Current Zoning: R-3 (single family residential)
Proposed Zoning: R-8MF(CD) (multi-family residential, conditional)

Approximately 2.46 acres located on the north side of Johnston Oehler Road and south side of Interstate 485, west of Mallard Creek Road.

The petition proposes to allow a mix of quadraplexes and duplex containing up to 19 residential units on a parcel currently developed with a single family home and a barn.

Staff recommends approval of this petition upon resolution of outstanding issues related to environment and site and building design.

RZ-2

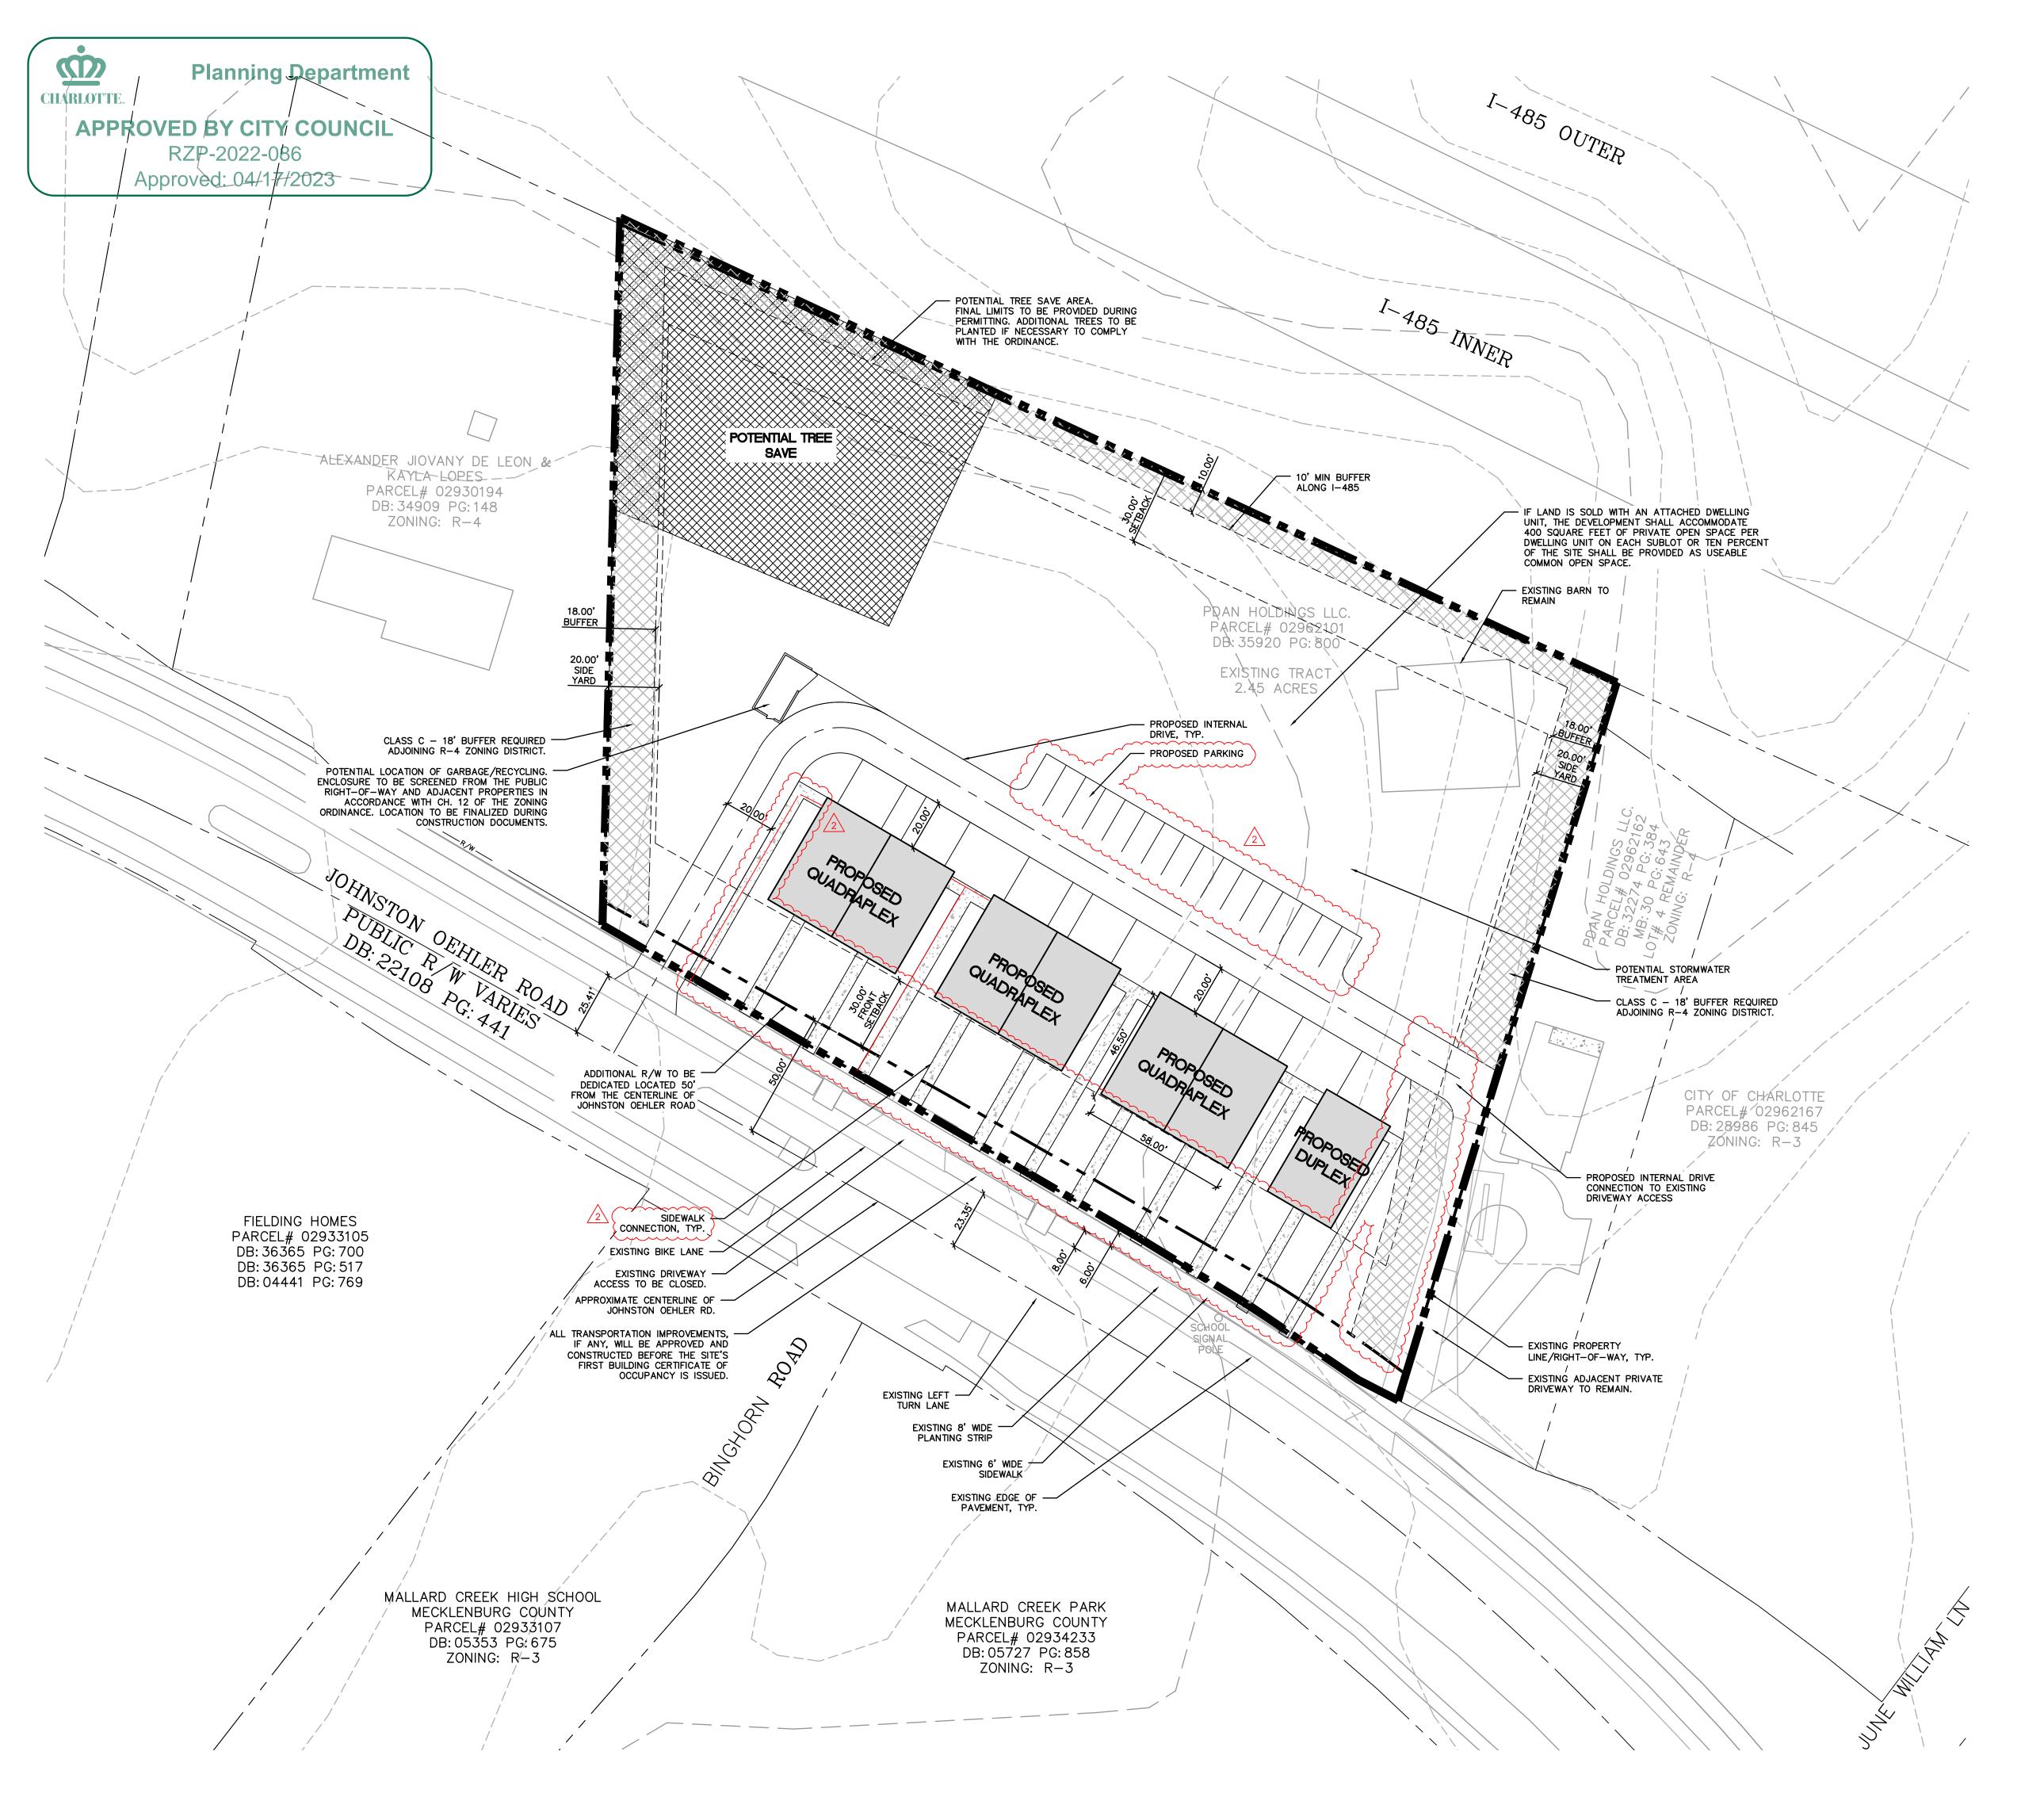
1. Part of what is shown would not qualify as protected tree save. This will either need to be adjusted to protect existing trees and/or additional tree save would be required. **Update:** Petitioner must show acceptable tree save on rezoning plan. Replanted tree save is not an available option.

RZ-2

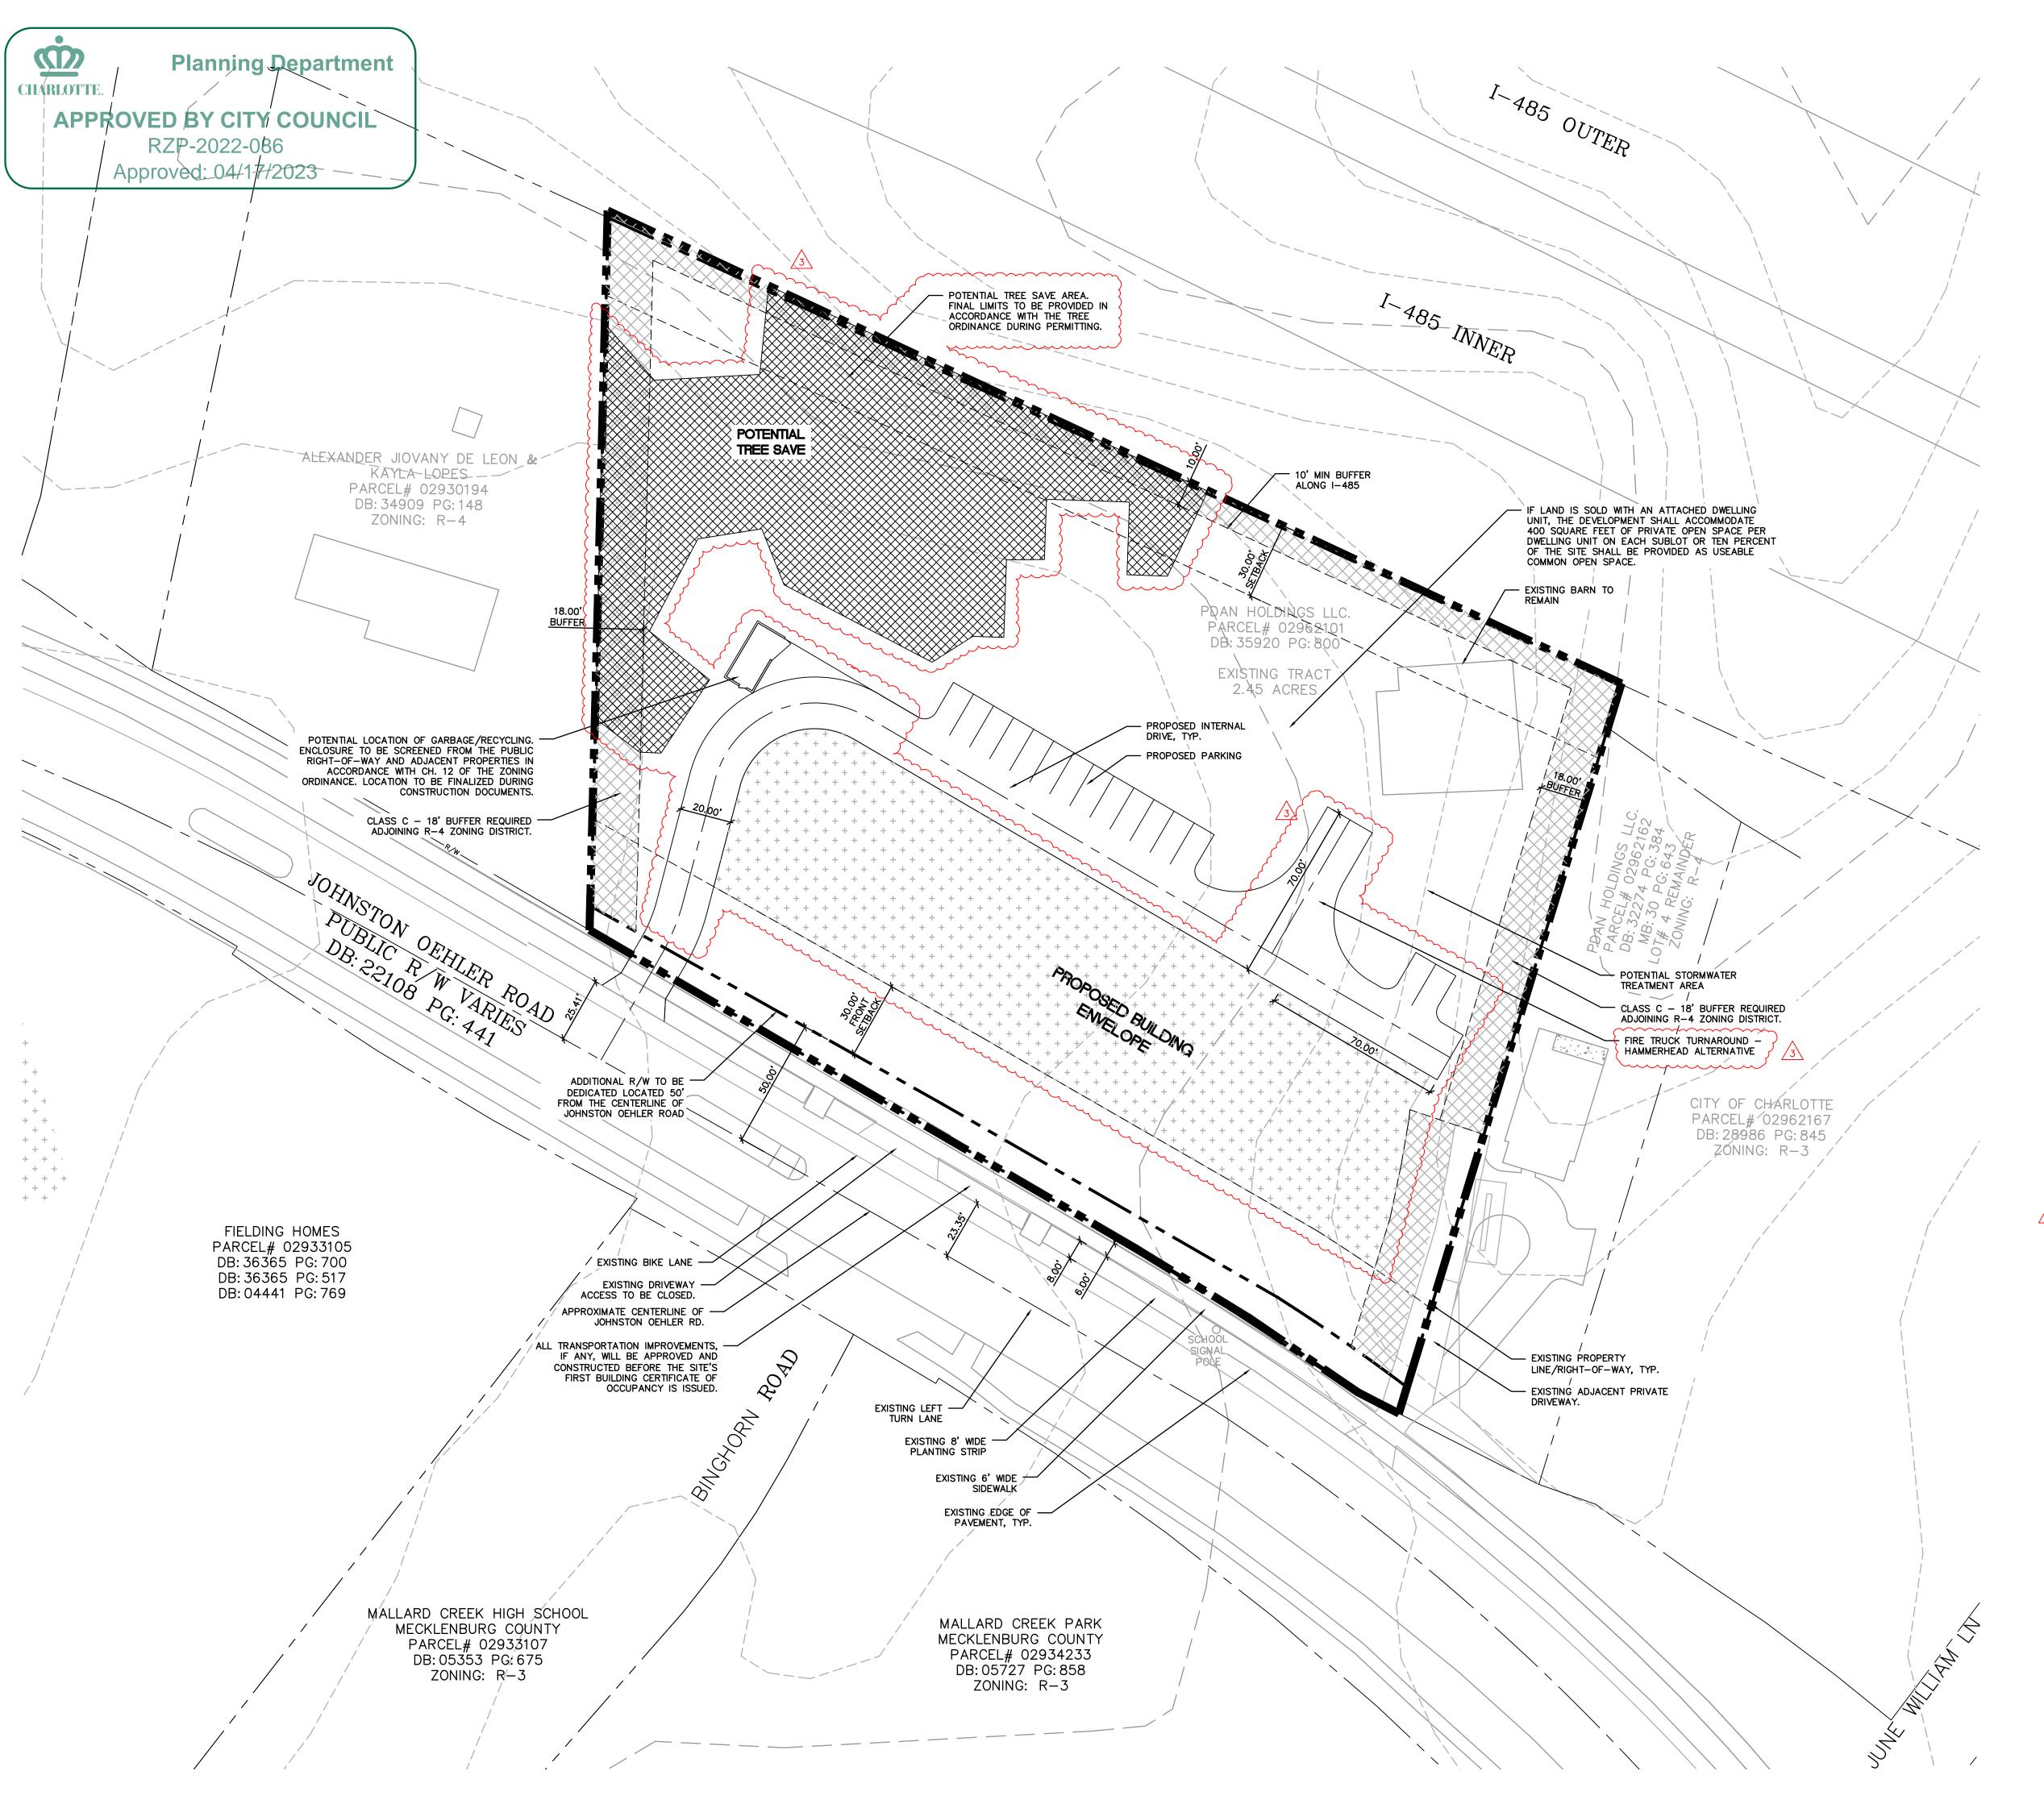
7. **New Comment:** The driveway connection to parcel 02962162 would not be allowed because parcel 02962162 is zoned R-4. Planned multi-family developments cannot be accessed through R-4 zoning.

Parcel 02962162 would need to be rezoned to a district that allows for Planned multi-family developments to allow for the driveway connection.
